Unit 9 Salt Box Field Land off Rowan Way Bersted PO22 9NW

Planning Reference: BE/53/22/DOC

At this stage we would not recommend discharge of conditions until the following comments are addressed in relation to conditions 12- Maintenance and Management of Surface Water

Basic Silt Trap by Polypipe

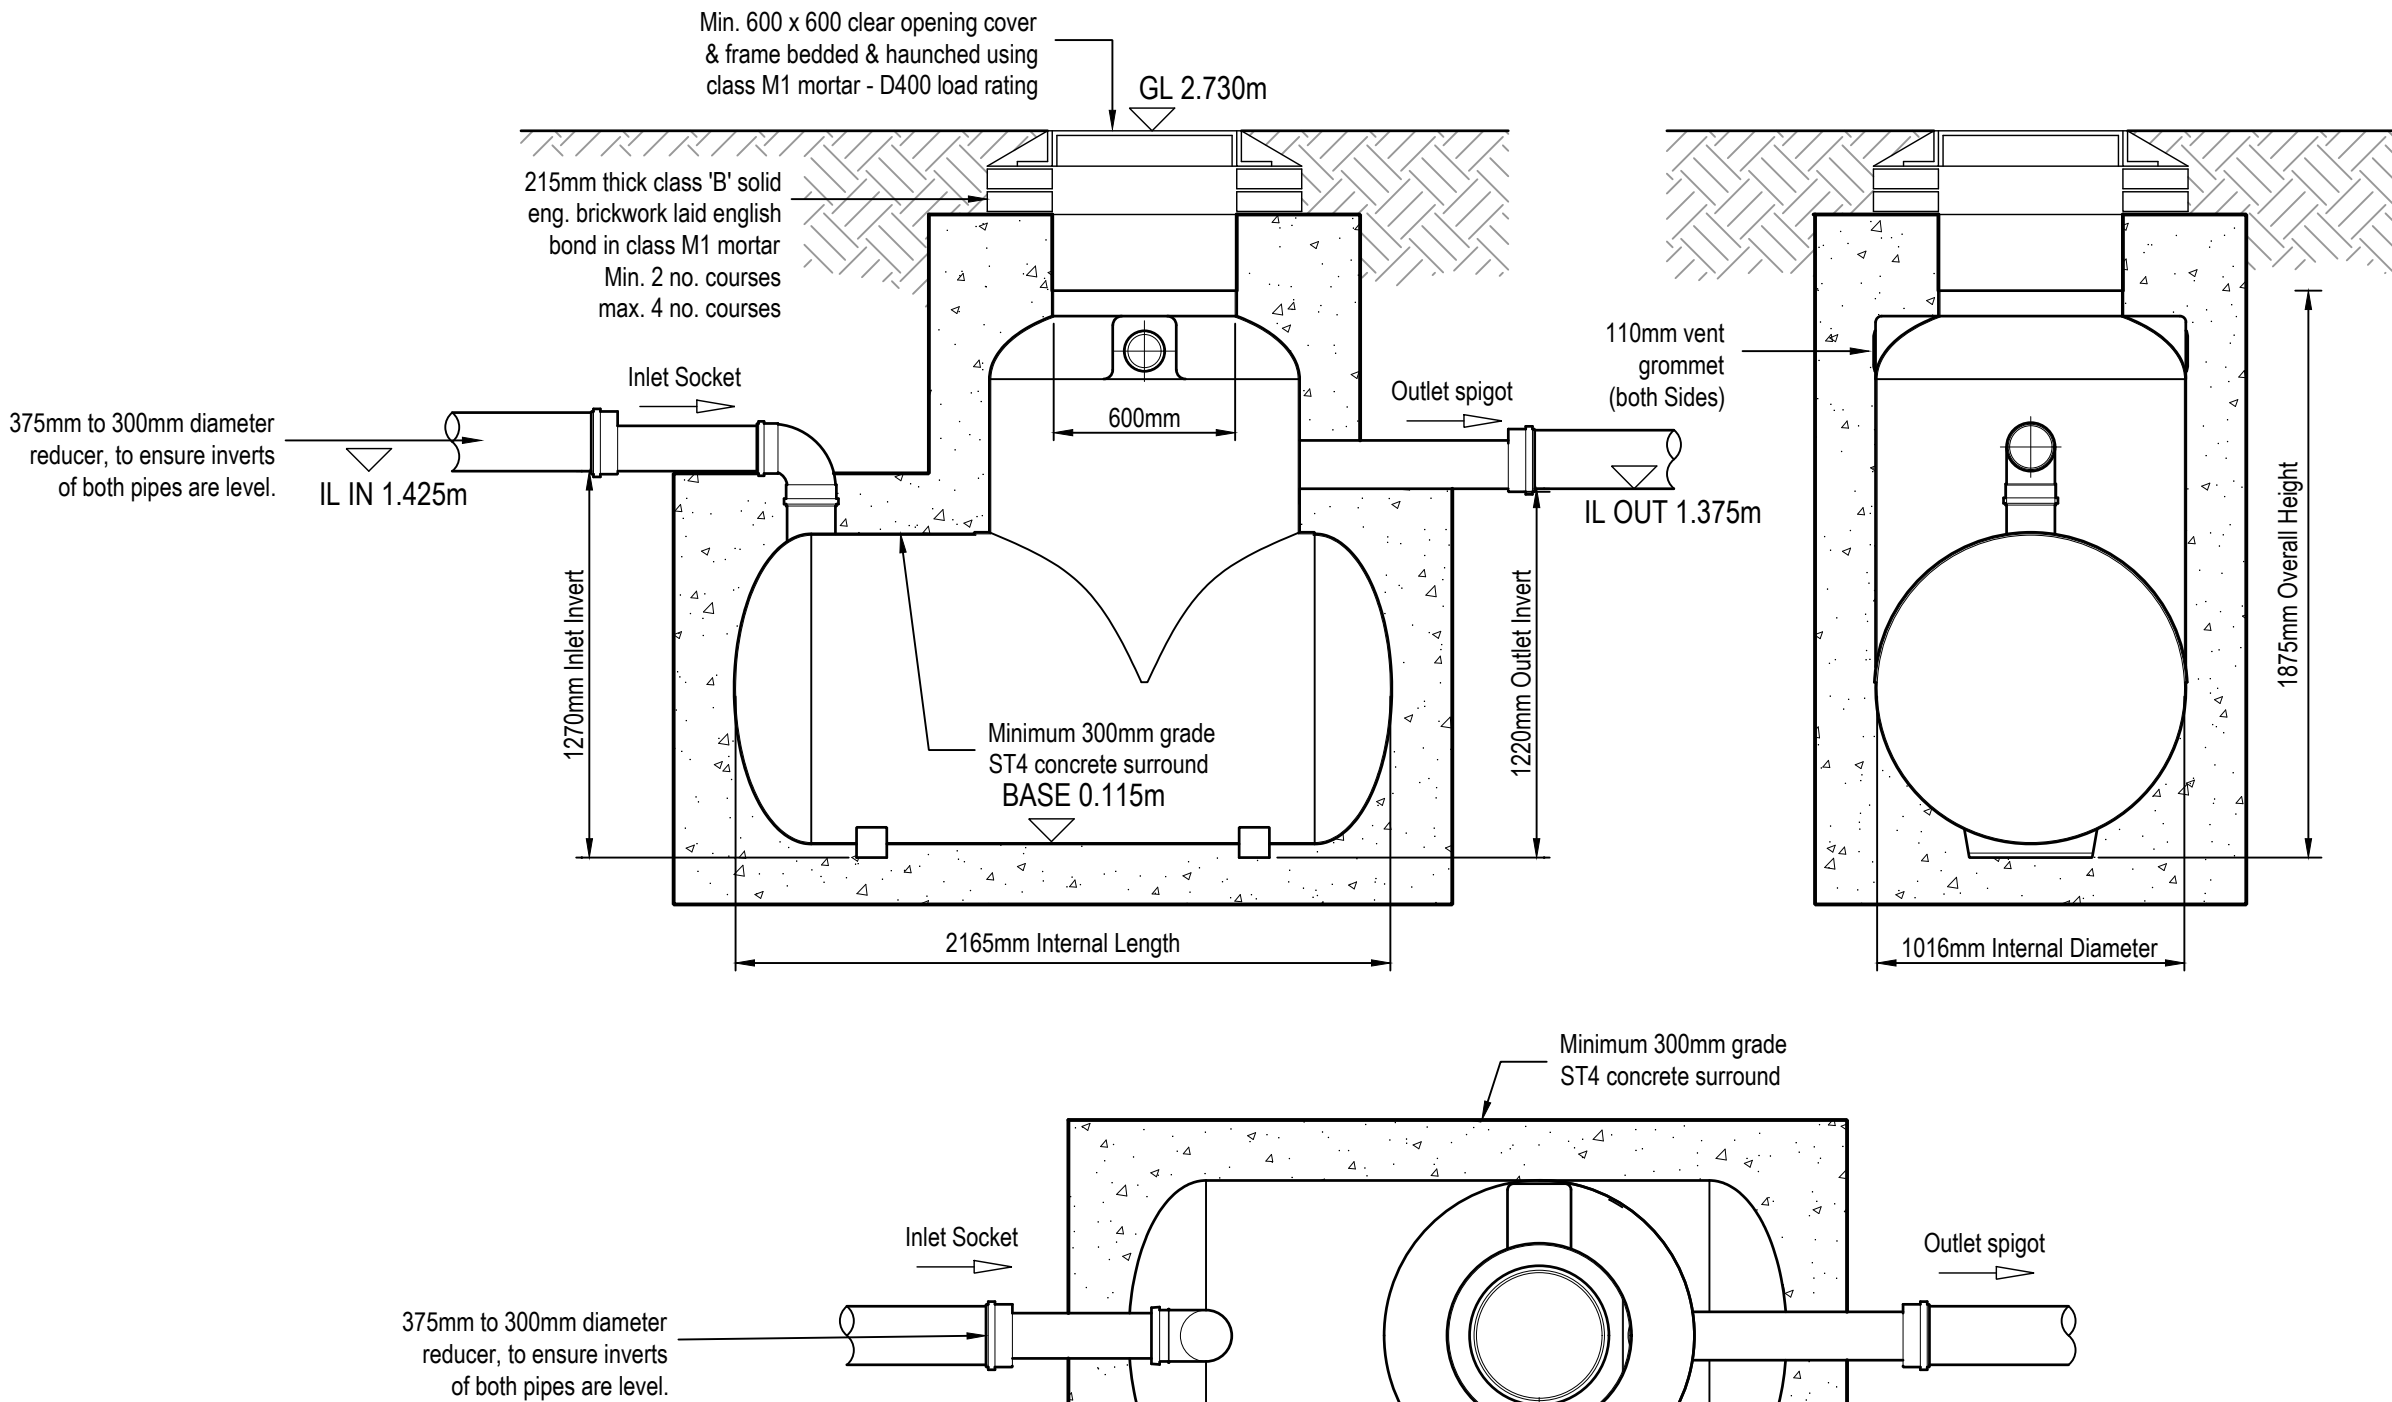
Construction Details of the washdown silt box needs to be provided- updated comments 26/04/23 – this information is still outstanding. The information provided in the updated Manual is just the product information brochure from Kingspan. A construction detail of this site box needs to be produced in relation to the site-specific drainage network, clearly identifying the invert connection levels and cover levels.

Hydrobrake Manhole in Tubosider Tank
Construction Detail

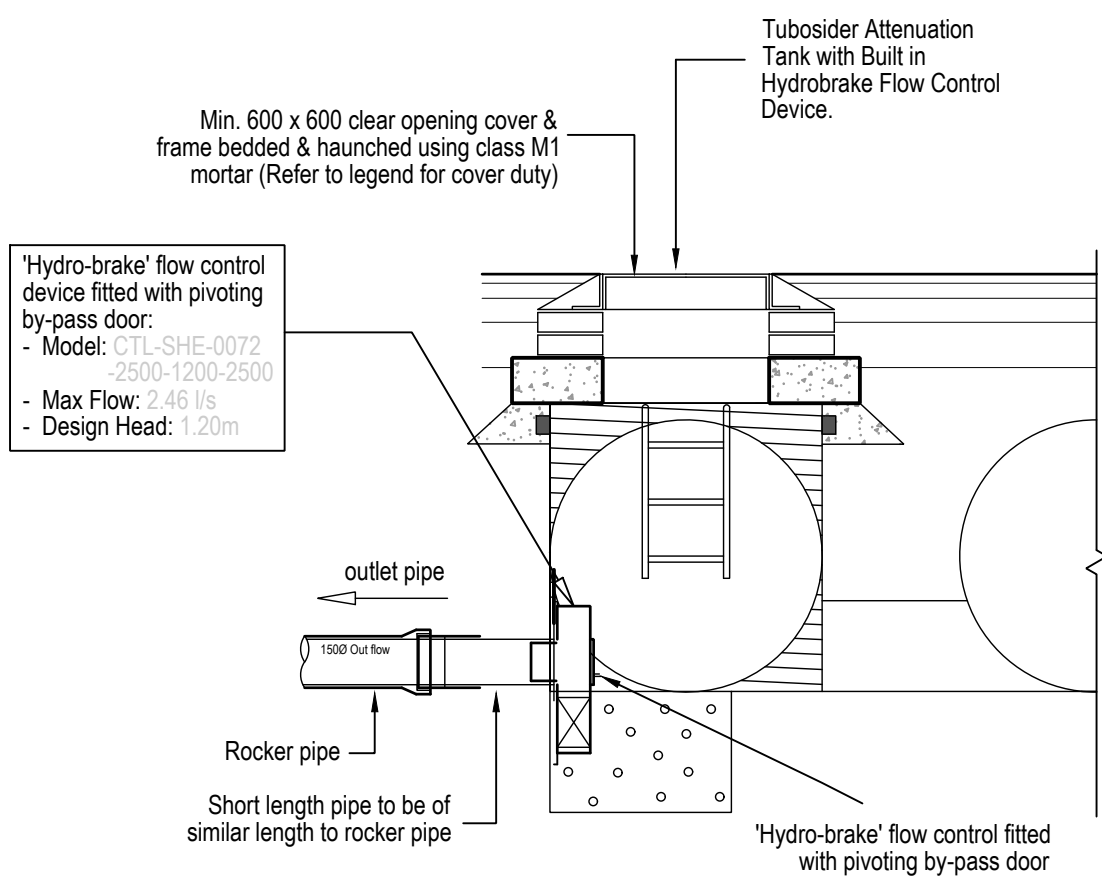
A construction detail on the Hydrobrake manhole needs to be provided and showing clearly how it ties into the proprietary attenuation system, this is important to ensure that future maintenance requirements within this manhole is clear- updated comments 26/04/23 – this information has still not been provided, the detail is not clear on how the Hydrobrake interface and will be fitted within the tank and chamber. Further details are required.
